Nottinghamshire County Council

Local Impact Report – Steeple Renewable Project

Steeple Renewables Project
Figure 1: Proposed Trench Plan and Geophysical Survey Interpretation Data

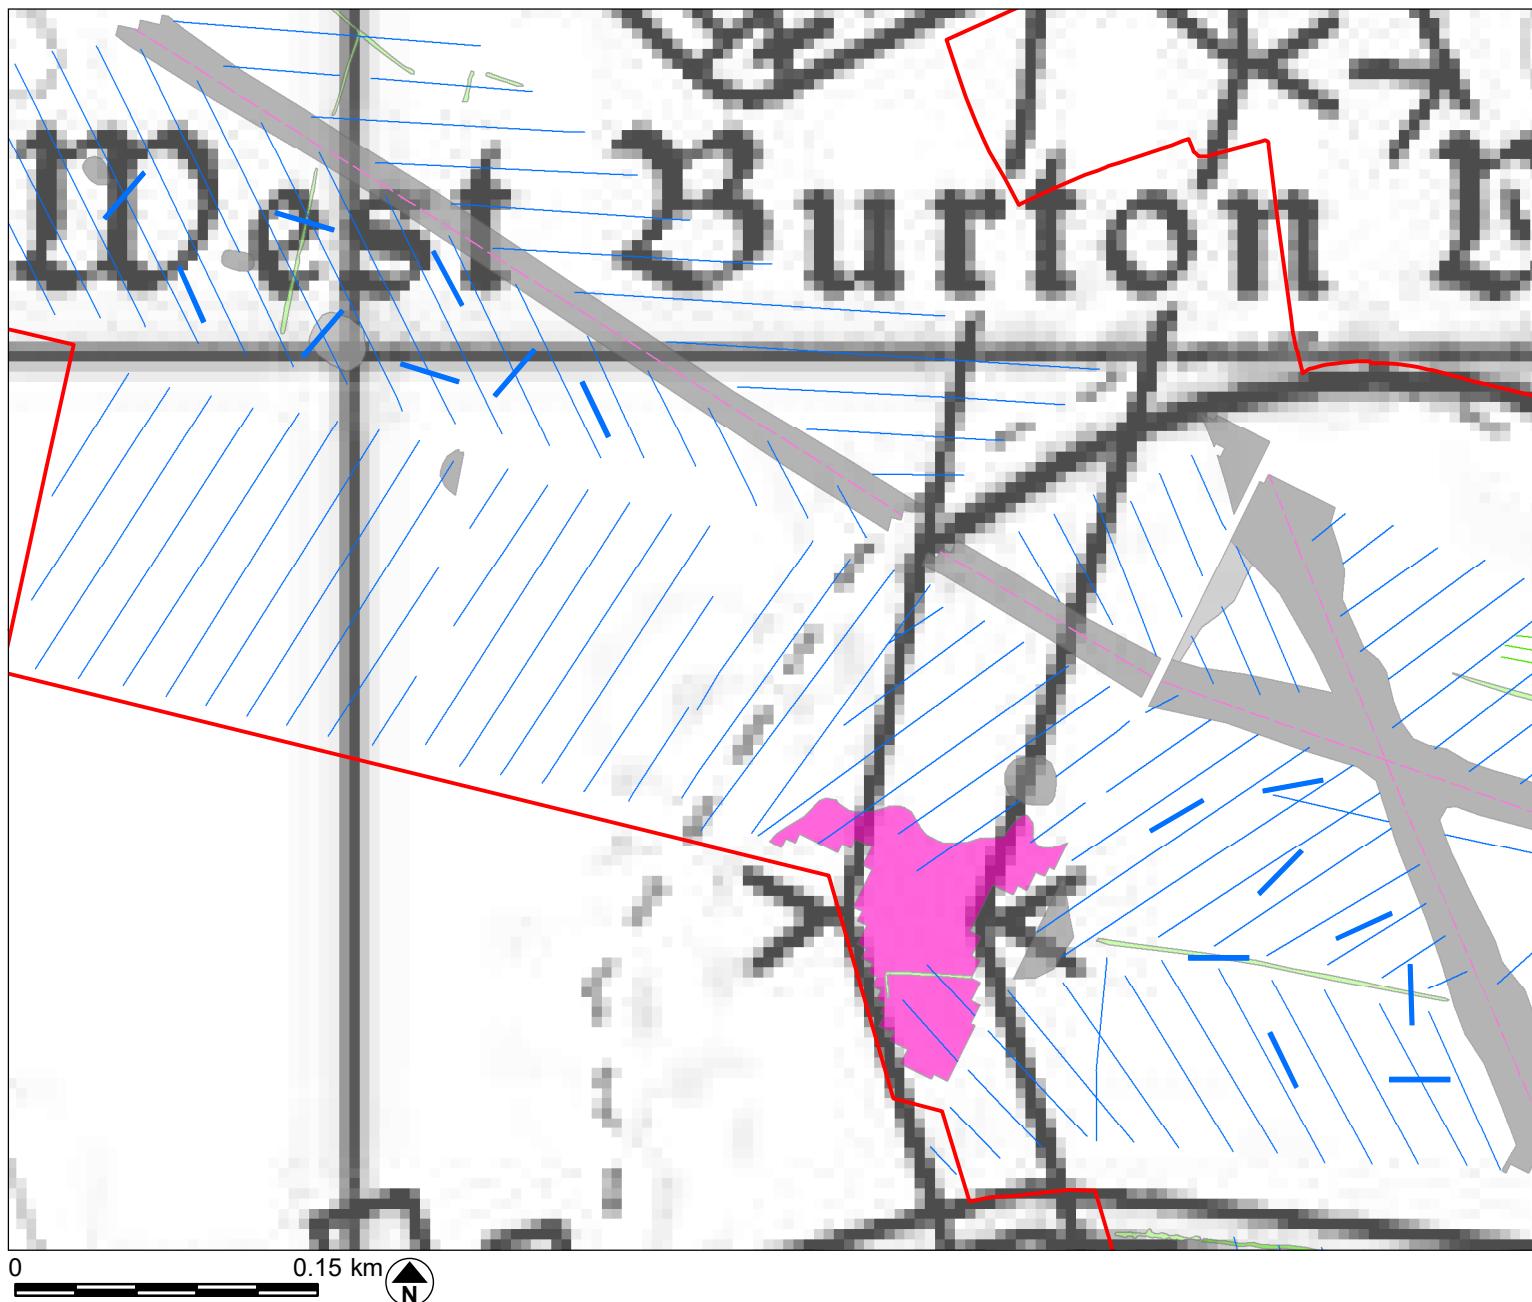
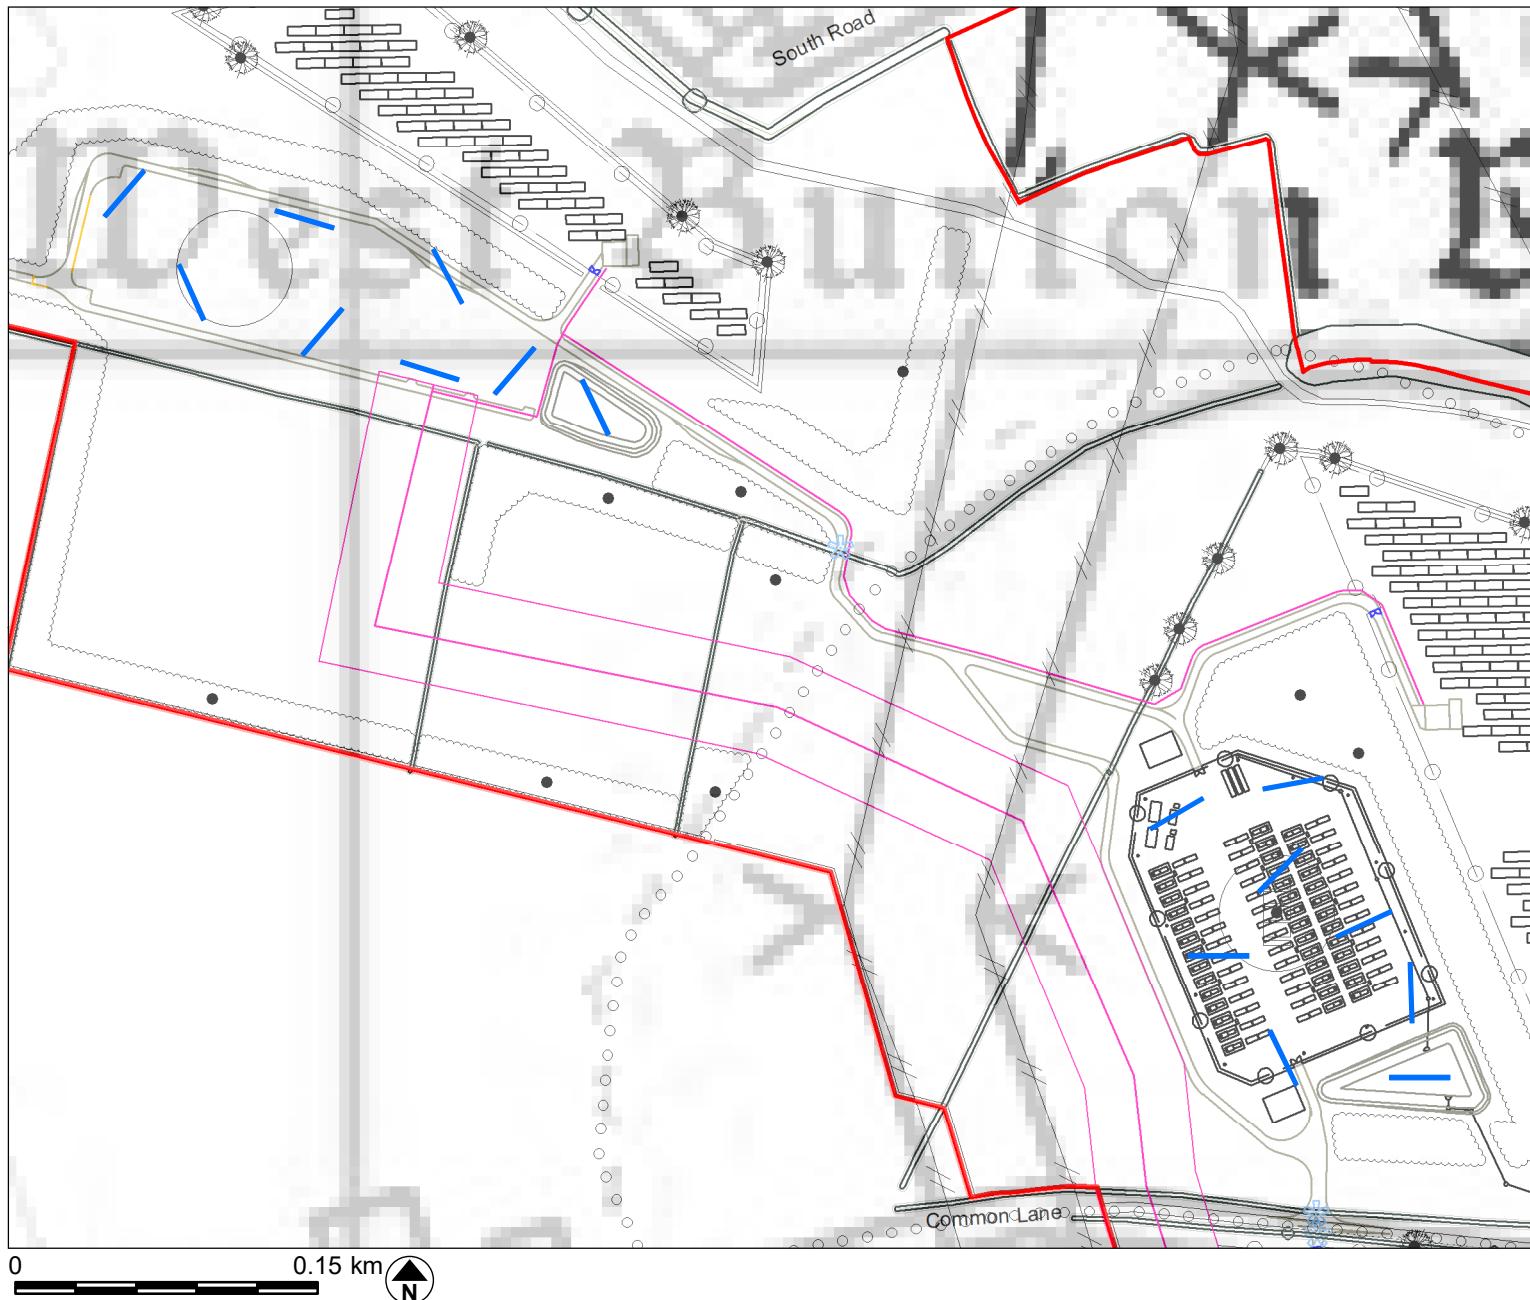
5.2.8. **The applicant has recently undertaken limited trial trench evaluation of the BESS and substation compounds comprising 16 trenches. While this is welcomed, the overwhelming majority of the site remains un-evaluated and in a state where the applicant does not understand the archaeological resource sufficiently to assess the proposed development impact.**

5.2.9. The pre-determination trenching is confined to the BESS and substation area and does not include other areas of infrastructure such as new roads/tracks, cable trenching for both for connecting rows of panel arrays and for grid connection, or for landscaping and ecological management areas. It also fails to include the areas of archaeological sensitivity that their own assessment work has identified.
